Our Ref: N:\37672 Northbank\Worddocs\Report\Submission NSW DoPI 7 February 2013

7 February 2013

NORTHBANK ENTERPRISE HUB (MP 10_0185)

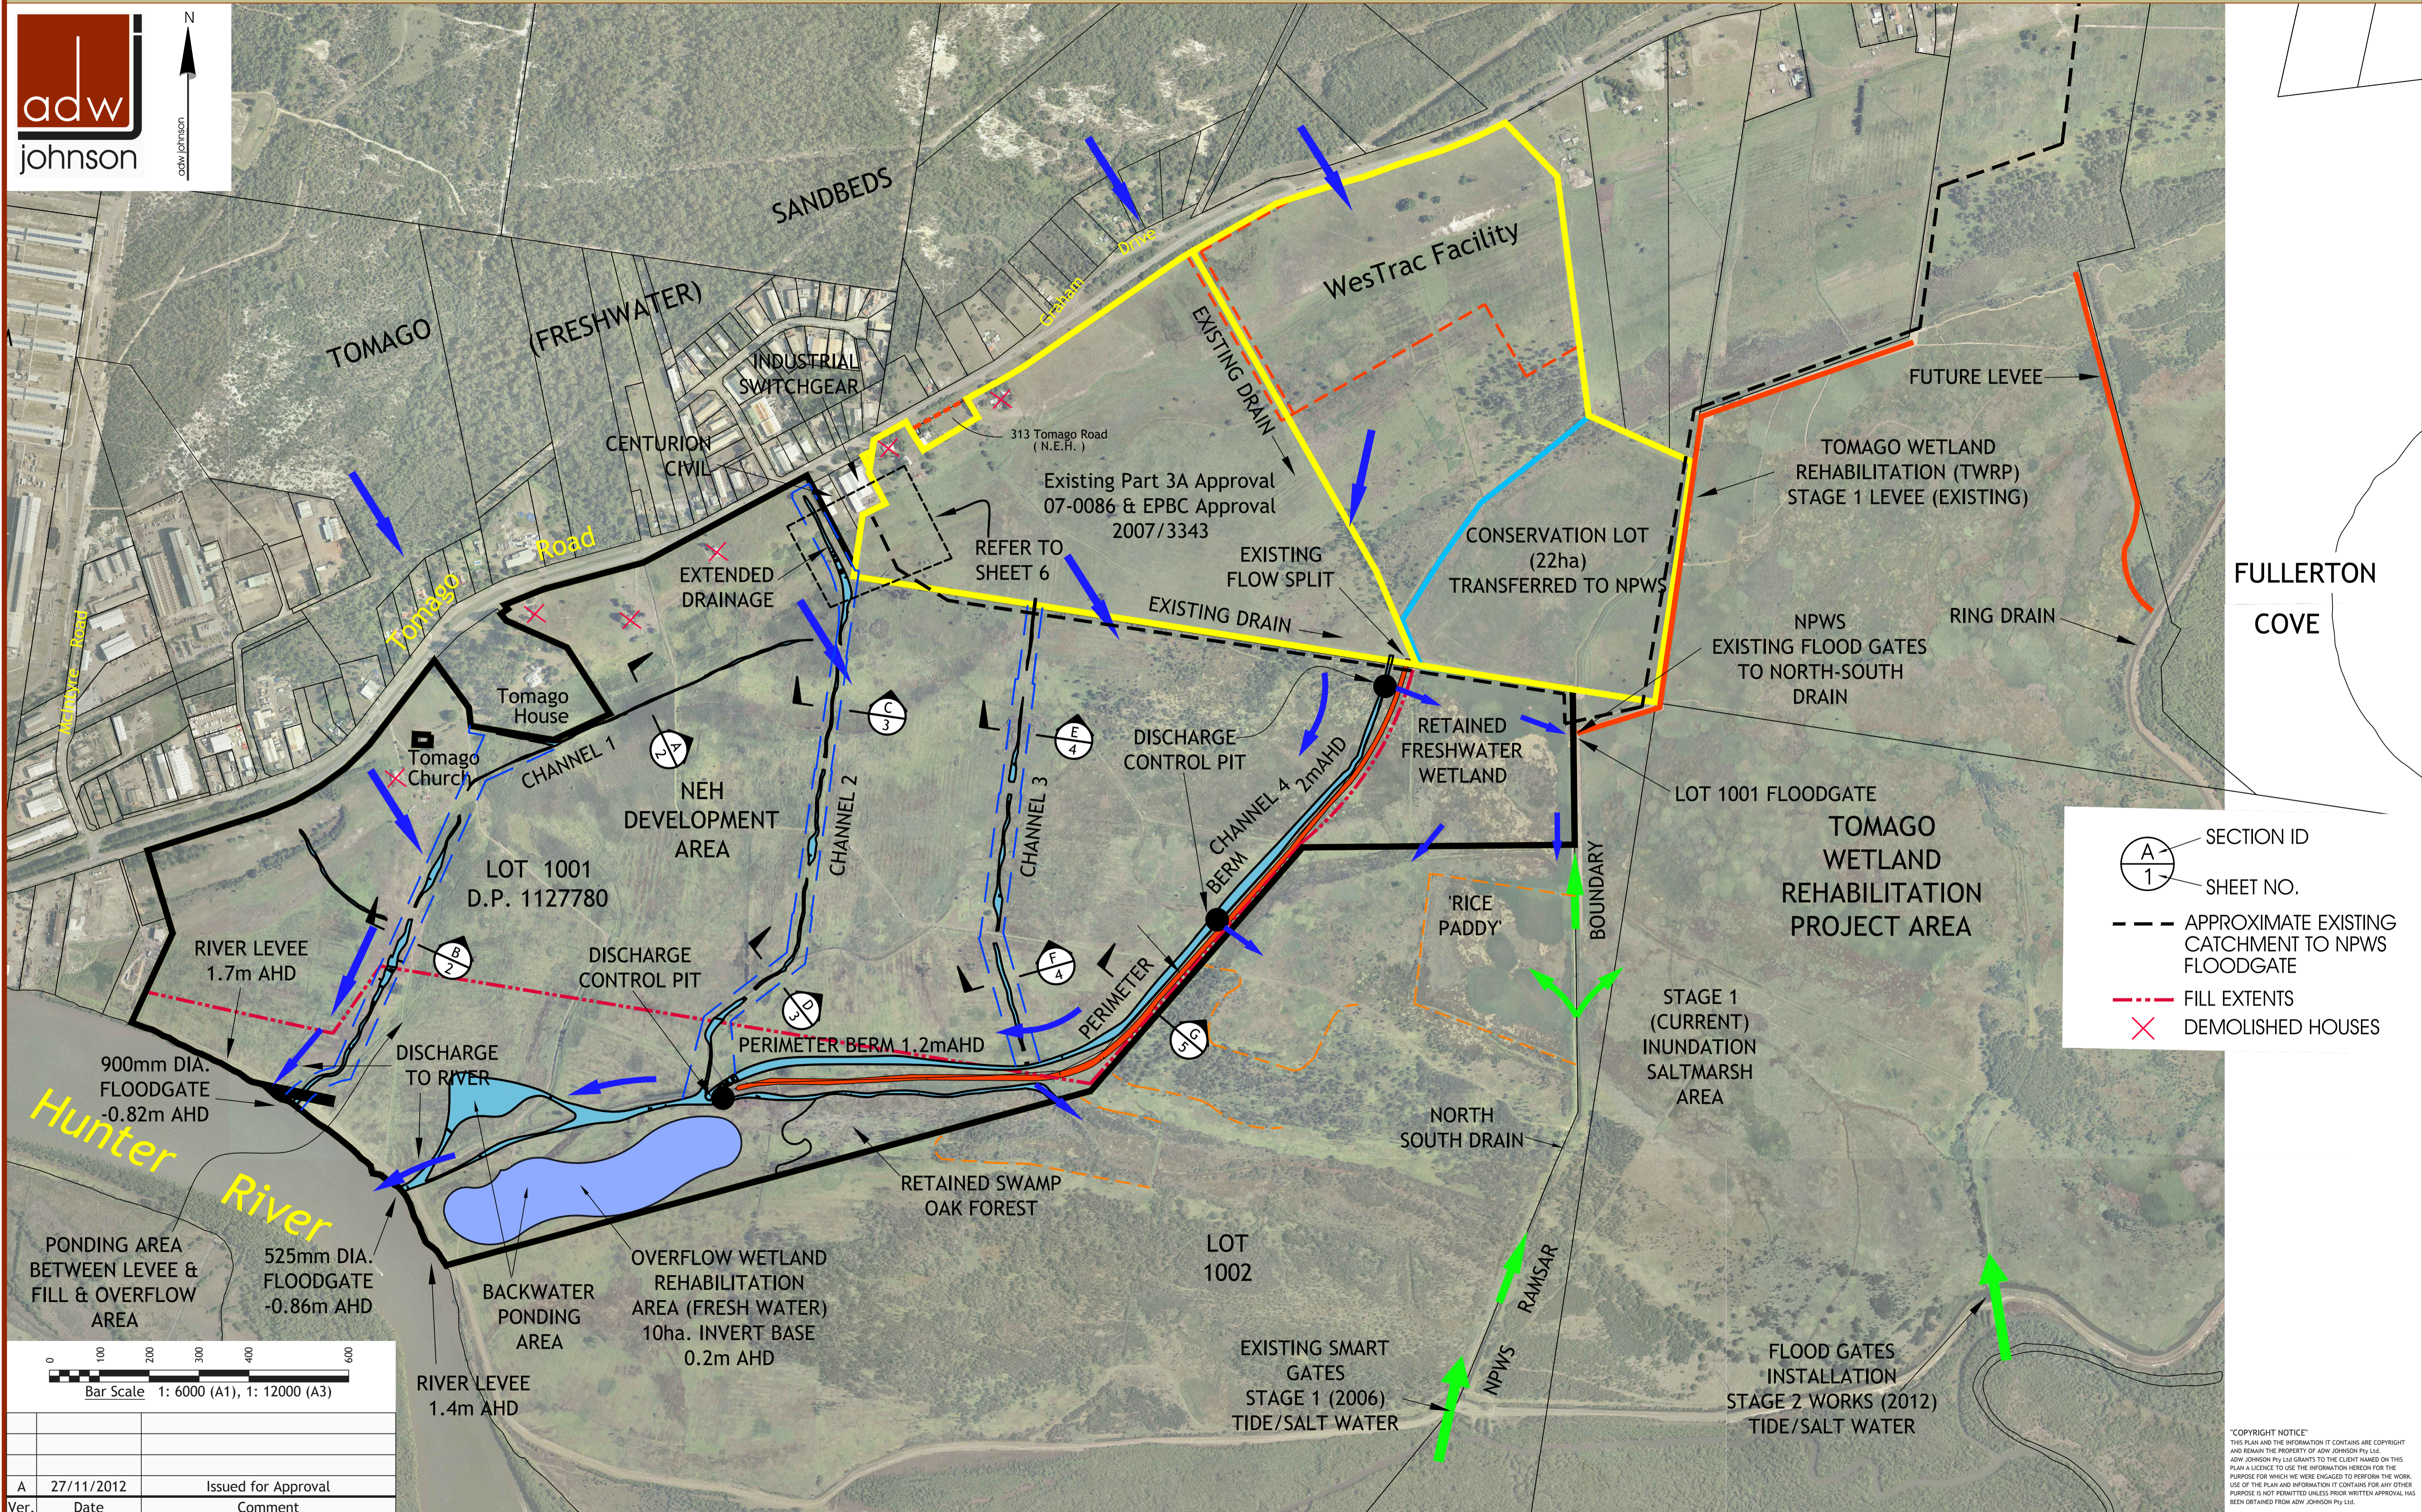
- *Additional information, including a catchment map of the areas north and west of Tomago Rd which drain through the site (if any areas west of Tomago Rd do drain through the site) as this is currently unclear;*

External catchment delineation has been added to Sheet 1 of the existing set of plan sheets from the previously submitted Attachment 'B' (see submission dated 12 December 2012). Survey has confirmed that the box culvert under Tomago Road east of Tomago House has an invert level of 2.3mAHD. The box culvert is 1.2m wide x 0.3 high. The upslope catchment area of Lot 1001 is approximately 45ha over highly permeable sands and contains a number of sinks or low points which would accumulate stormwater prior to runoff to the culvert. Surface runoff is expected to be very low, whilst contribution to groundwater flows will be very high by comparison to conventional stormwater runoff and infiltration. The culvert level does however give good indication for peak acceptable levels of ponding within Lot 1001 without impeding any upstream flows drained through this culvert. BMT WBM's peak flood level for Channel 2 which will take this runoff is approximately 2.1mAHD, indicating that flow is not impeded during this event. Similarly, piped drainage from the small industrial subdivision north of Centurion Civil and Industrial Switchgear also within the catchment is also unimpeded.
